City of Albuquerque

December 11, 2001

Re: Certification Submittal for Final Building Certificate of Occupancy for
HB Construction, [C16 / D6N]
3400 Vista Alameda
Engineer's Stamp Dated 12/06/01

RE: ALAMEDA BUSINESS PARK LOT 13 (C-16/D6N)
(3400 Vista Alameda NE) (HB Construction Building)
ENGINEERS CERTIFICATION FOR CERTIFICATE OF OCCUPANCY
ENGINEERS STAMP DATED 5/1/2001
ENGINEERS CERTIFICATION DATED 12/4/2001

HB Construction Office
GRADING and DRAINAGE PLAN

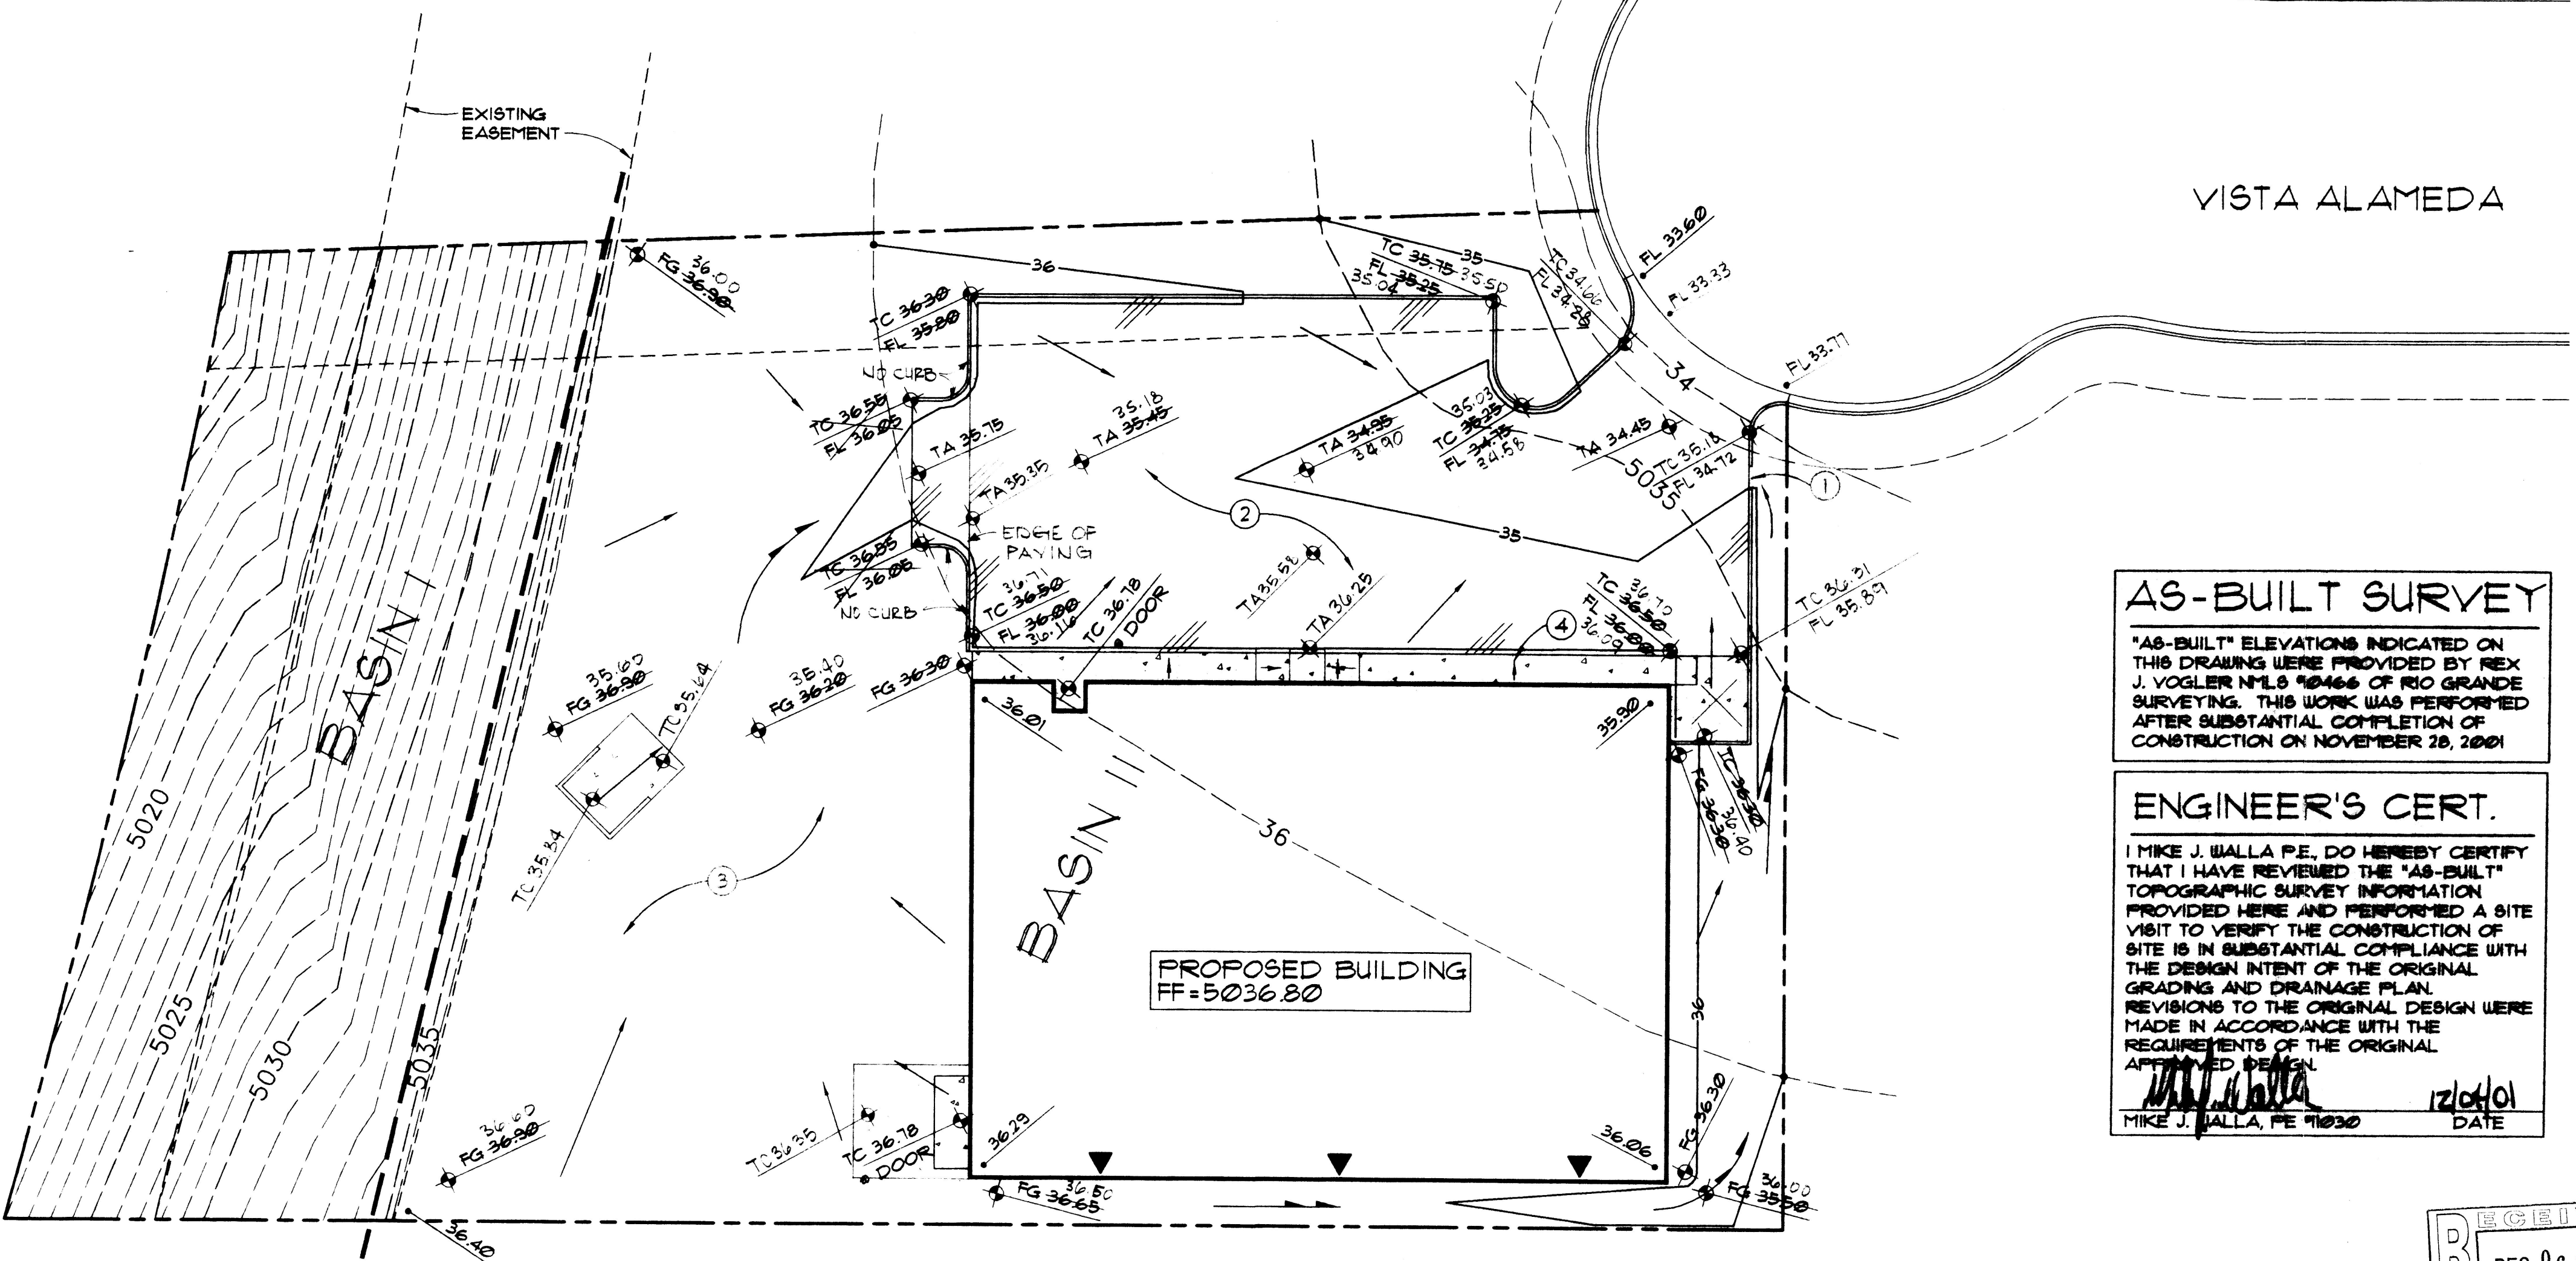
In reviewing your Engineers Certification submitted to our office, for the above project, there was a major change in the grading and drainage plan after Hydrology had approved the grading and drainage plans. Any major changes should be resubmitted to our office for review and approval prior to construction and request for Certificate of Occupancy.

- Elimination of the curb break for drainage flow and the gravel lay down area was not approved in the grading and drainage plan previously approved for building permit. Please notch out the curb break for proper drainage flow and replace gravel which was removed.
